**Consultation Response from: KC Environmental Health (Pollution & Noise Control)**

**2023/92966 - Land to the rear of 271 Cliffe Lane, Gomersal, Cleckheaton, BD19 4SB**

**Demolition of existing dwelling and erection of 87 dwellings including formation of a new access from Cliffe Lane, landscaping, public open space and all associated infrastructure and engineering works**

**Responding Date:**  
15<sup>th</sup> January 2024

Figure 3 – Conceptual Site Model

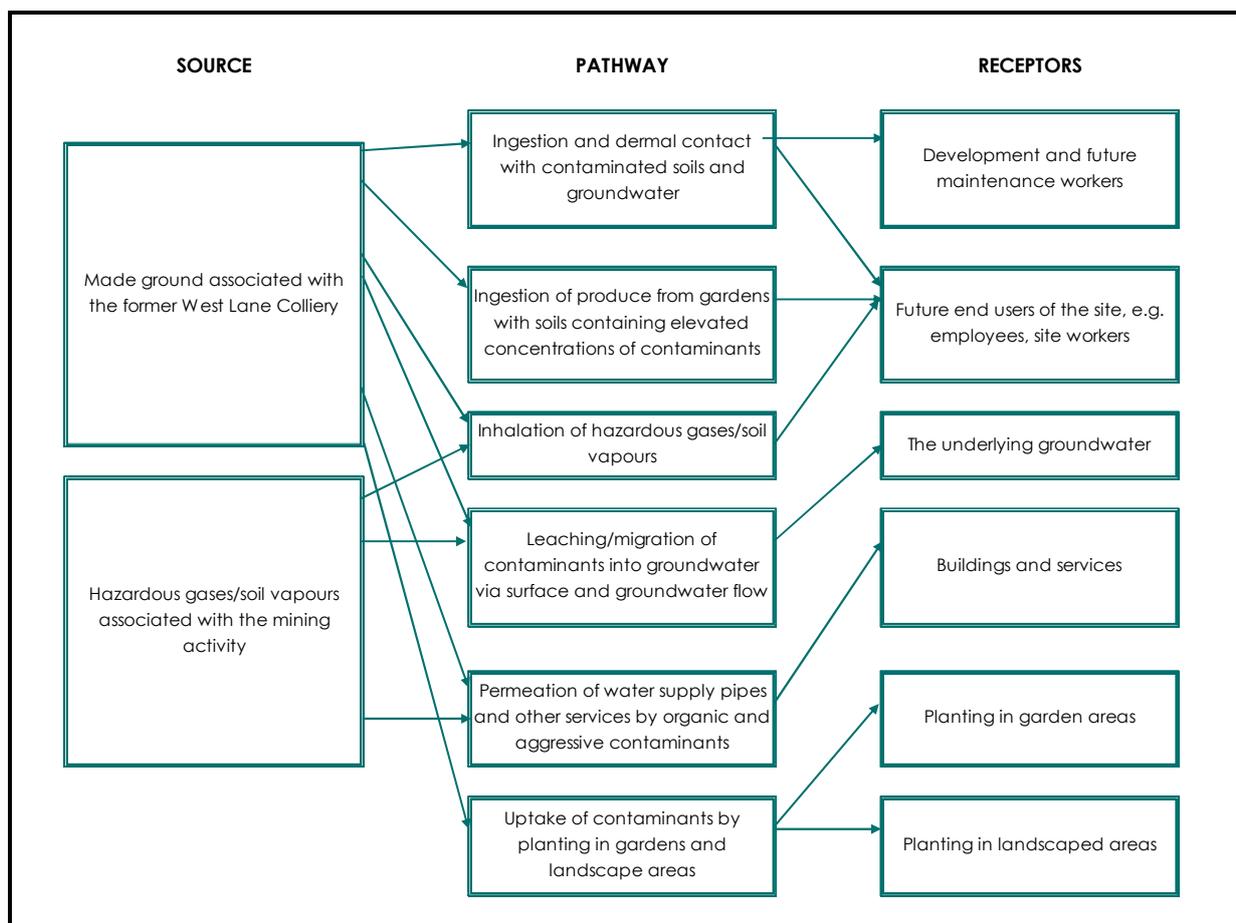
- (1) The monitoring results are described as preliminary but refers to the site being classified as Characteristic Situation 2 according to CIRIA 665. Has the applicant undertaken any further monitoring since the report was authored?
- (2) The conceptual site model does not include risk from spontaneous combustion/combustible materials, despite a risk identified in the report.
